Application No: **FP/185/10**

Sub-division of existing dwelling to create 1no. 2 storey 3bed dwelling & 1no. single storey 2 bed dwelling with parking
15 Limmer Lane Felpham

**Sub-division of existing dwelling to create 1no. 2 storey 3bed dwelling & 1no. single storey 2 bed dwelling with parking
15 Limmer Lane Felpham**

Drawing Nº RTLL-2010-006

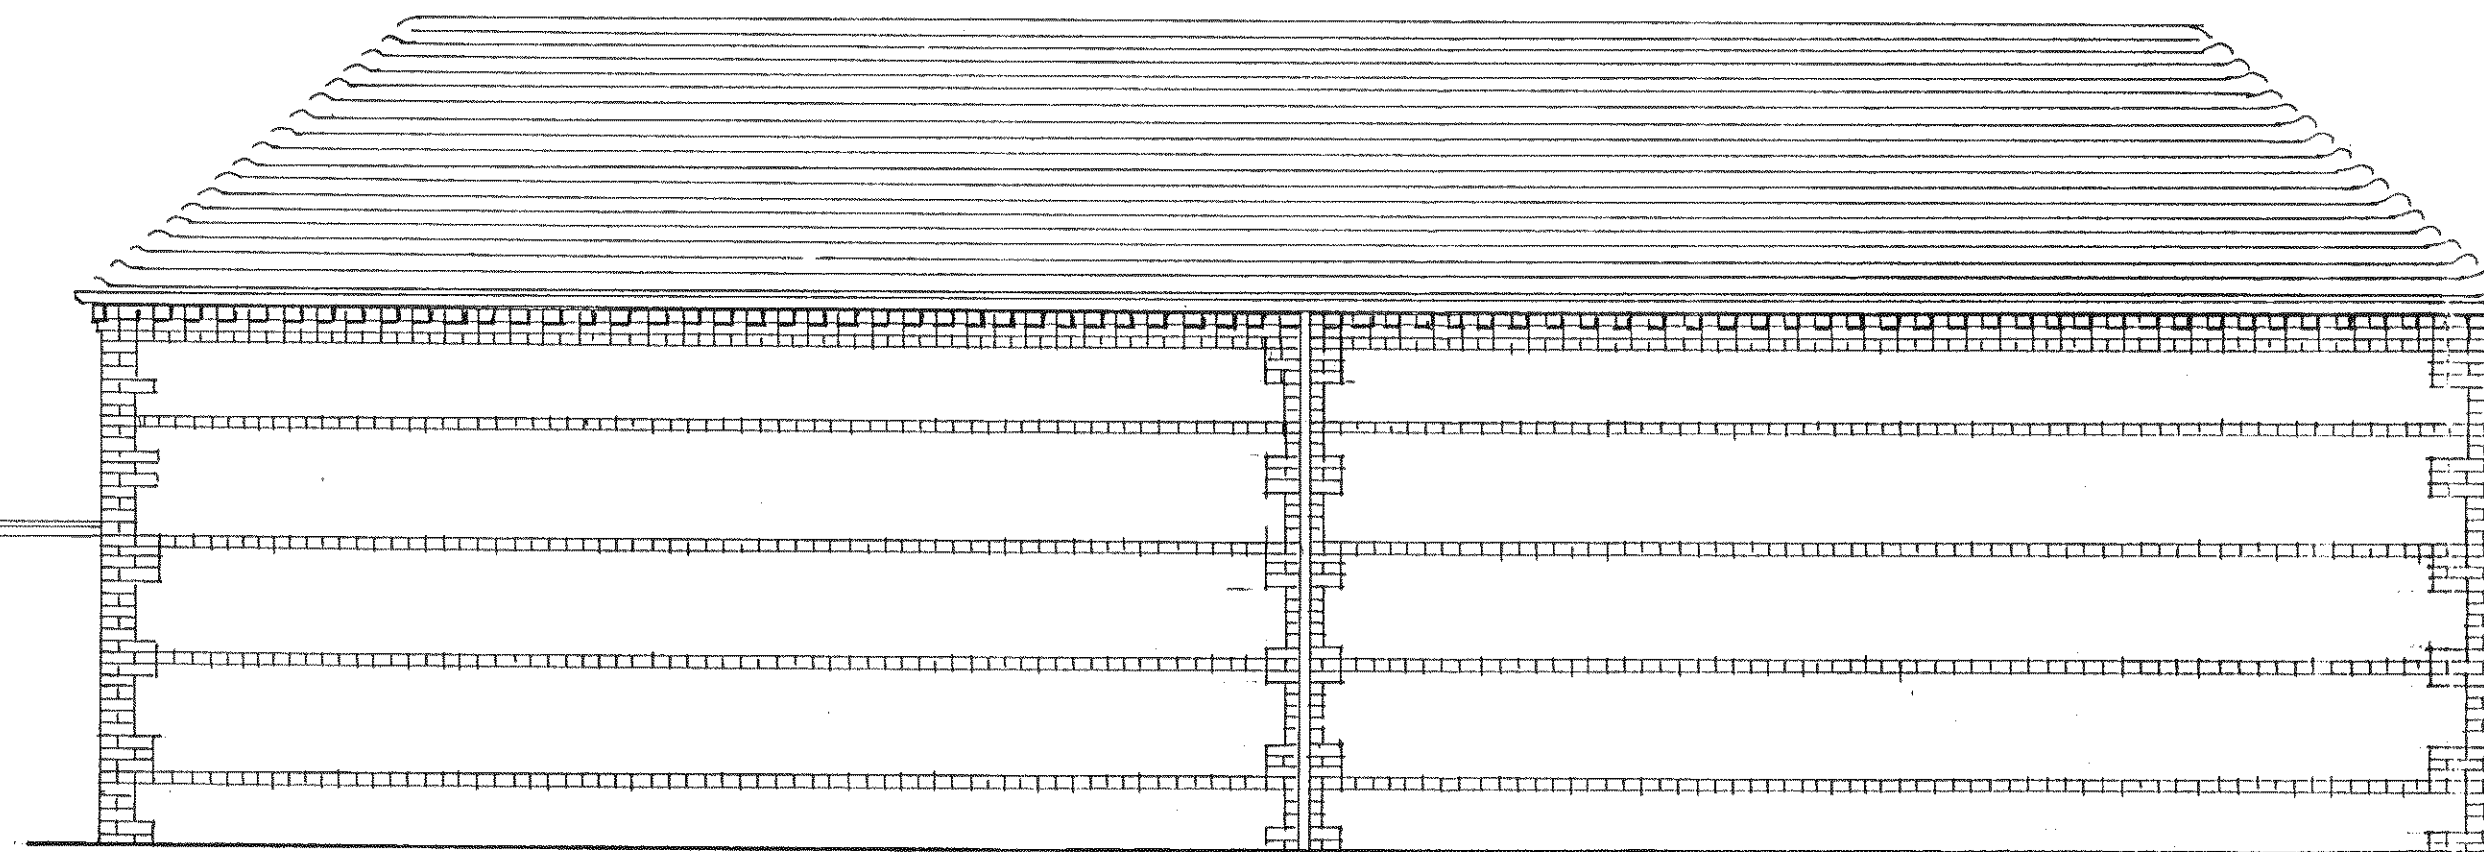
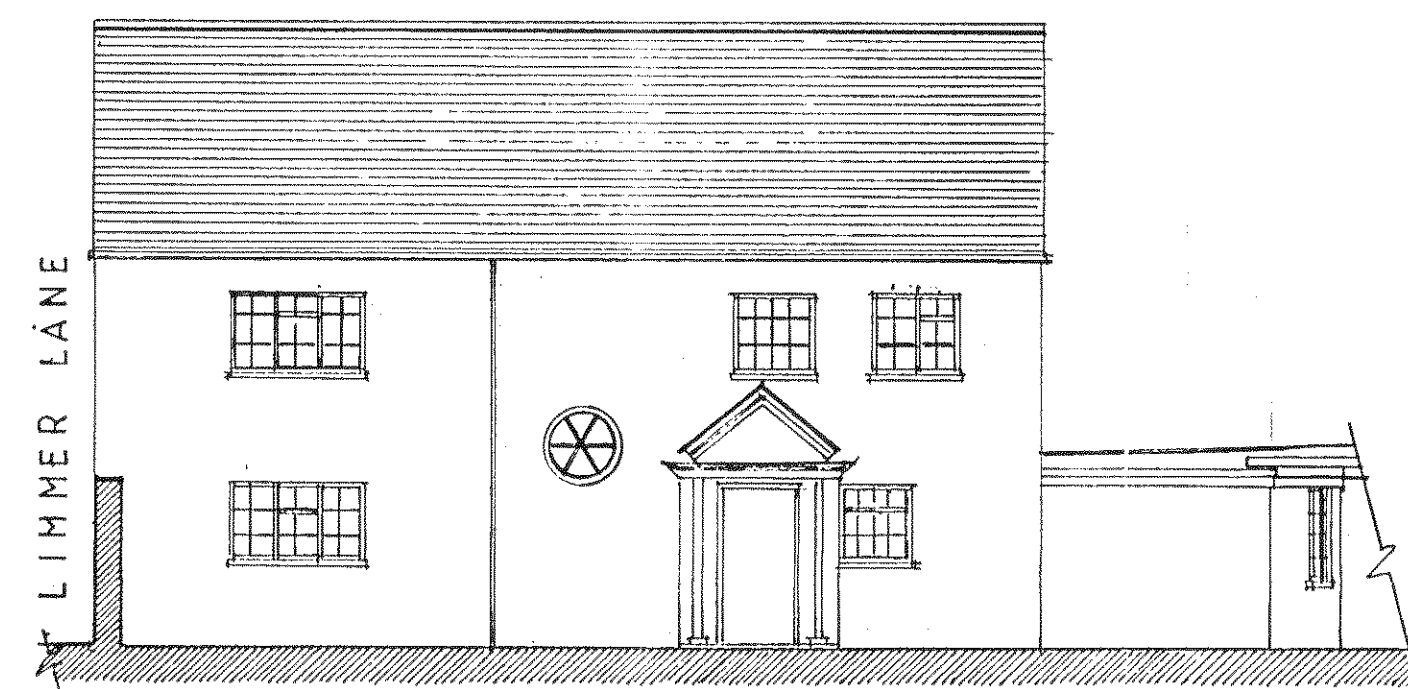
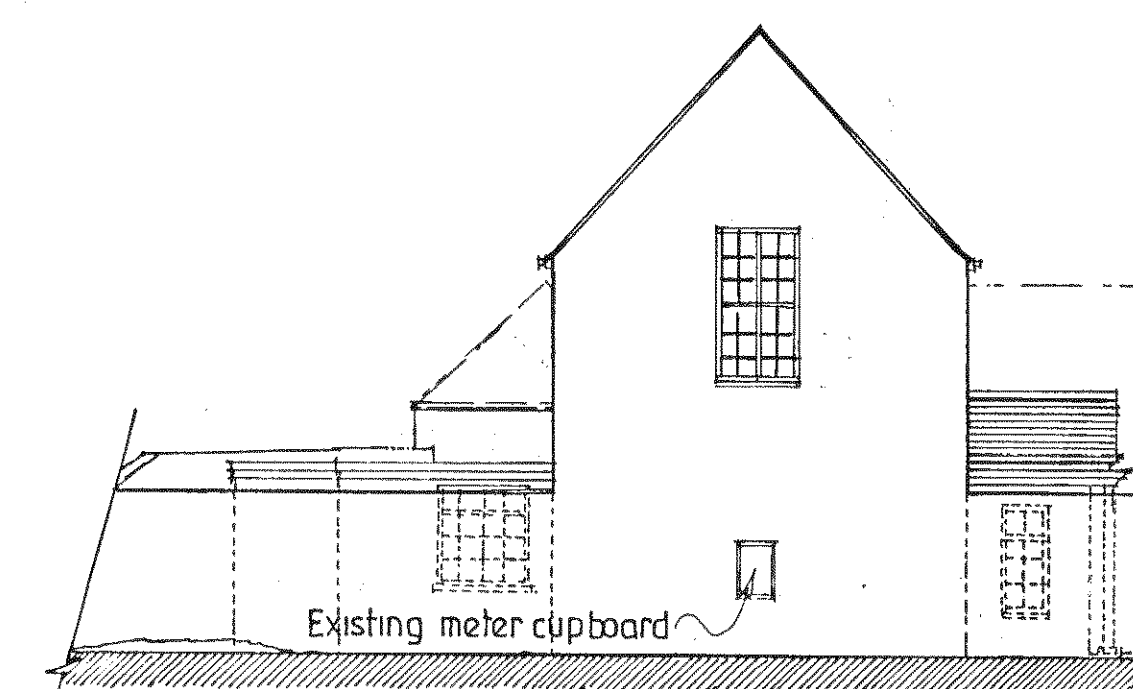
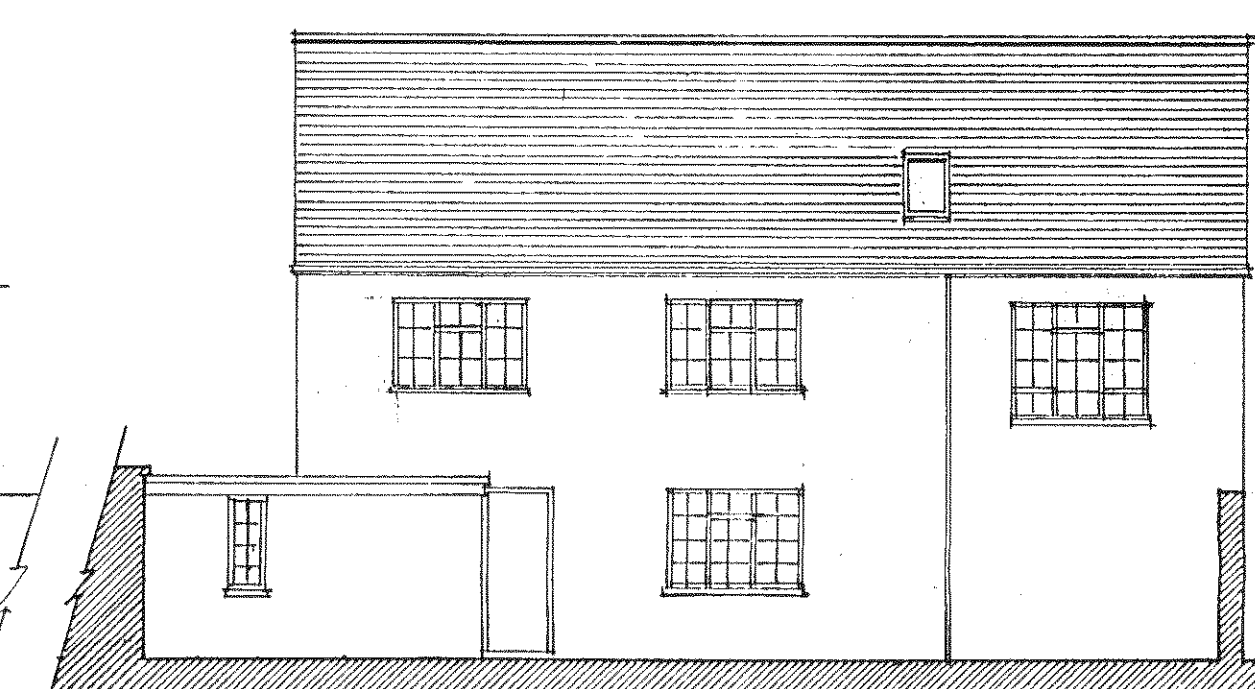
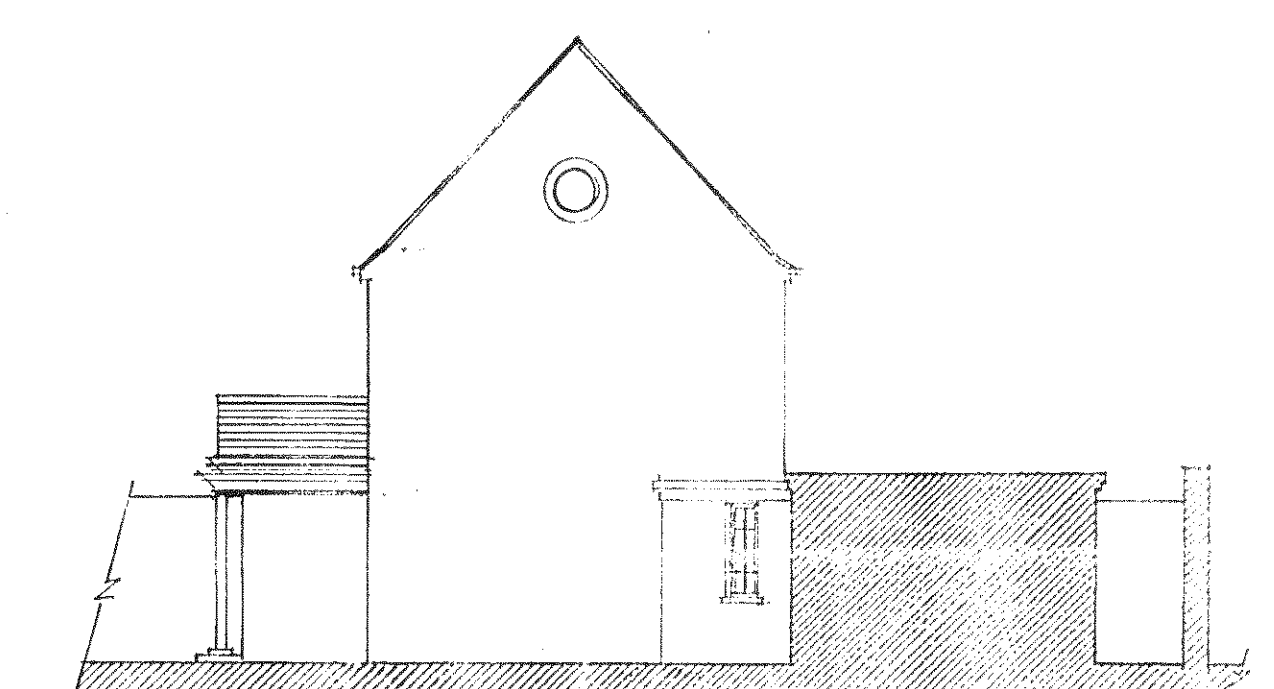
- The existing & proposed elevation facing west shows a roof light that is not shown on the floorplans/roofplan. Please amend accordingly.
- The existing & proposed elevation facing south shows a window on the ground floor which is not shown on the floor plans. Please amend accordingly.
- The existing & proposed elevation facing east does not show the porch detailed on the floor plans, and there is a circular window detailed on this elevation which is not shown on the floor plans. Please amend accordingly.

Drawing number RTLL-2010-006 Revision A now shows the north and south elevations of the existing porch to the two storey dwelling, although in the case of the south elevation the porch has been indicated as a broken line below the height of the 2.2 metre boundary wall bounding Limmer Lane which virtually conceals the porch.

We have also clarified that there is no second window in the south elevation gable onto Limmer Lane. This is in fact an existing meter cupboard and is now identified as such on the drawing.
